MEMORANDUM

Subject: Design Documentation - Proposed Roundabout at Meadowbrook Pkwy and Newt Dr

MEADOWBROOK PARKWAY ROUNDABOUT

ROUNDABOUT OVERVIEW

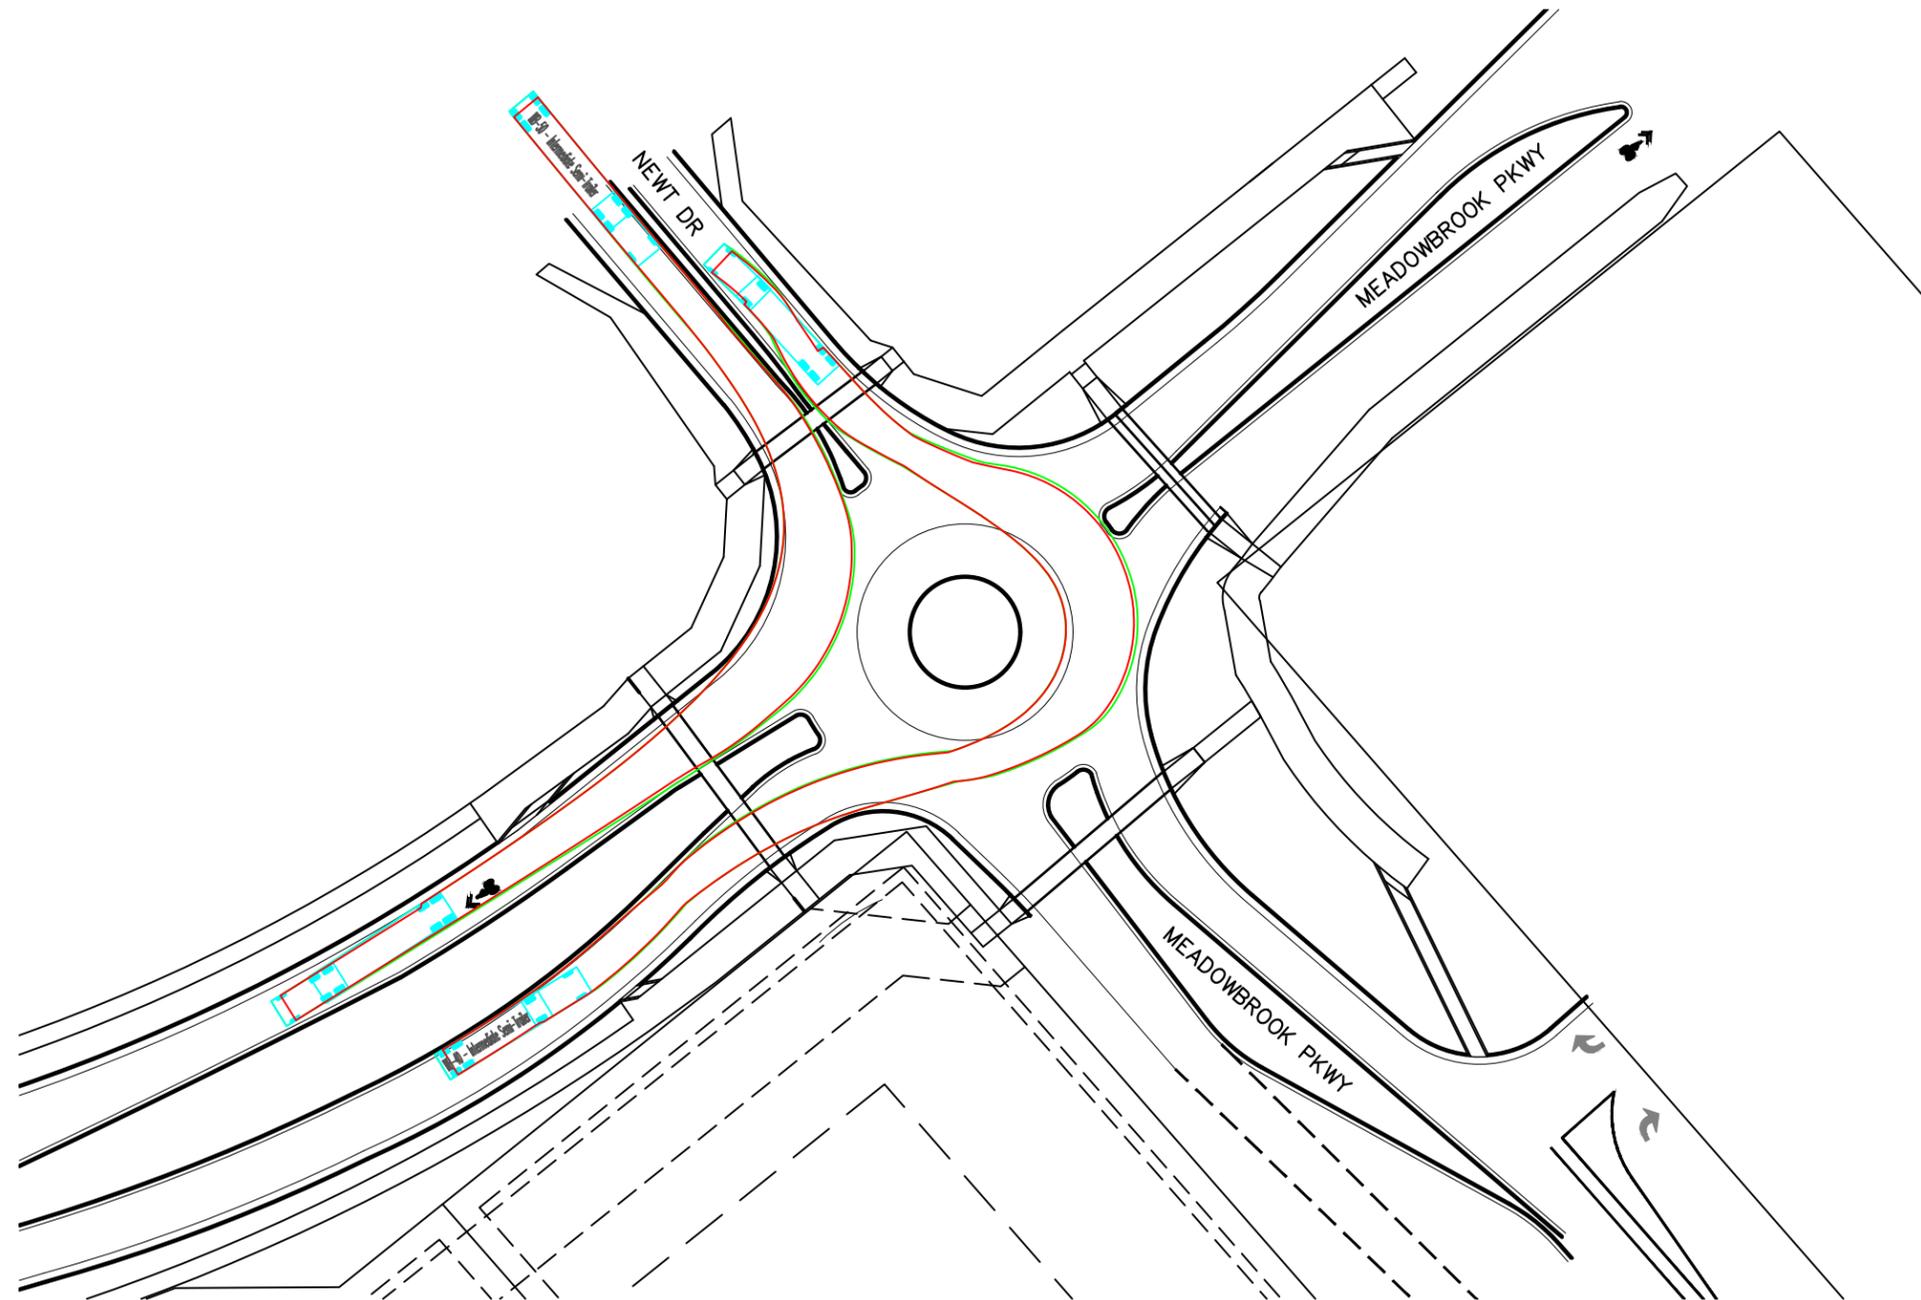
Provide clarification to the different widths.

Show/label the ROW lines

Update Roundabout to include Bike entrance and exit ramp design. See the WiDOT roundabout design for standard width for the shared-use path.

Label the width of the median. Required minimum width is 4'.
Width may need to be wider to accommodate a refuge area that meets ADA standards.

Adjust all pedestrian crossing to be perpendicular to the receiving ramp/refuge area.

show the existing sidewalks

Show the existing C&G.

TYPICAL SECTION APPROACH

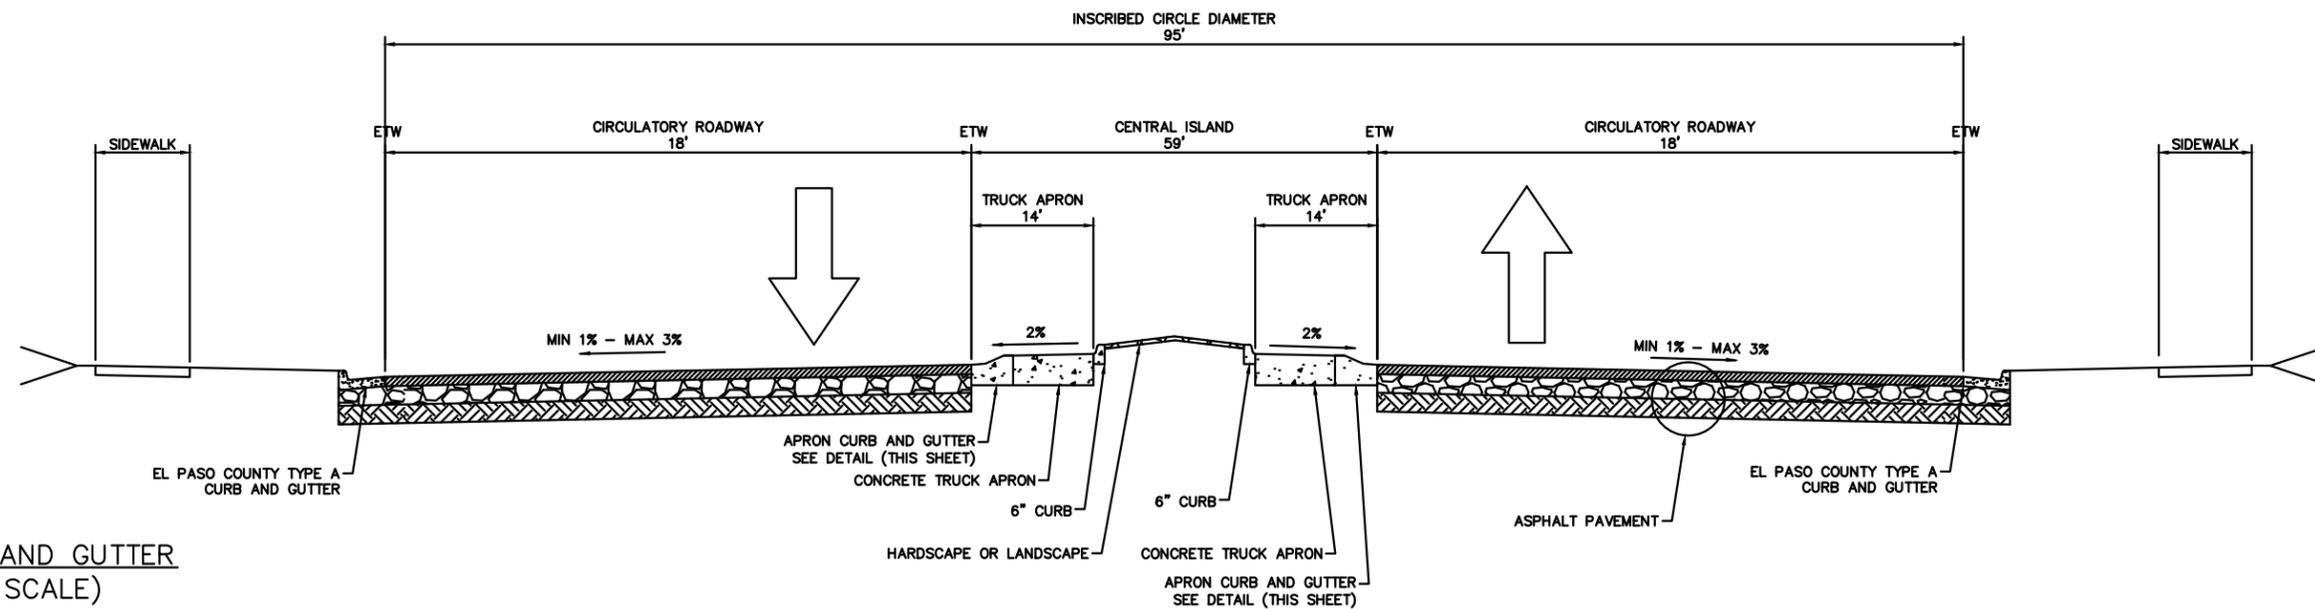
Revise splitter island C&G from mountable to El Paso County Type B C&G

Revise to EPC Type A

Update truck apron. Apron curb & gutter shall be per the detail below.
